## WEST SUSSEX COUNTY COUNCIL CONSULTATION

| <b>FROM:</b>                    | Stephen Gee WSCC - Highways Authority                                                                                                                                                                                                                                                                                                                                                                                                                                                                |
| <b>DATE:</b>                    | 8 July 2019                                                                                                                                                                                                                                                                                                                                                                                                                                                                                          |
| <b>SUBJECT:</b>                 | WA/48/19/RES<br><br>Approval for Reserved Matters following outline <u>per

Drawing Title
Planning Layout

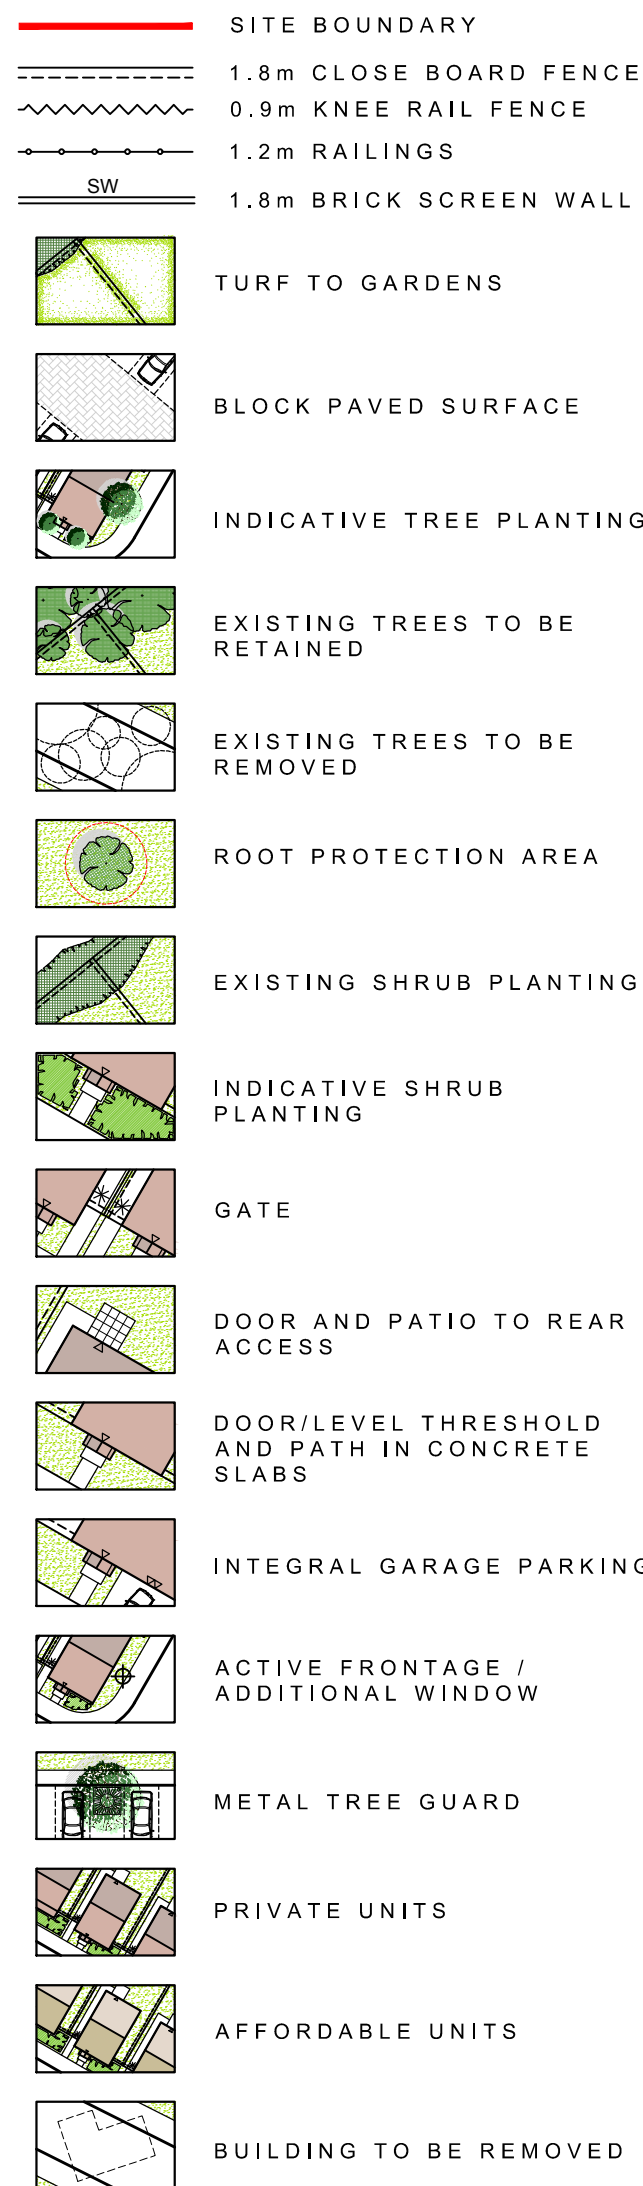
Whilst it is understood the relocation would encourage existing local residents to travel sustainably by reducing the distance to the facilities, for those choosing to drive the parking options to the north could be limited by existing parking along Arundel Road (depending on the future use of the centre). Depending on the time of day the traffic conditions at the A27/A29 may discourage vehicles to drive around to access the dedicated parking. It is noted the planning layout does not appear to be in keeping with approved access drawing ref 1186-02 Revision D.

Further consideration should be provided to the location of the community facility, parking provision and impact on Arundel Road.

The scheme may benefit from additional pedestrian links within the site such as the south east corner which creates a cul de sac (dwelling no 347 – 362) and if suitable more direct links from the central residential area (278-284) in to the open space.

The tracking shows a number of areas where the curb is over run by the refuse vehicle. The applicant should check the full extent of tracking provided and either re run the tracking exercise or amend the design.

One significant area highlighted is the retail and flat parking where the vehicle appears to travel over a kerbed space between the two parking areas.
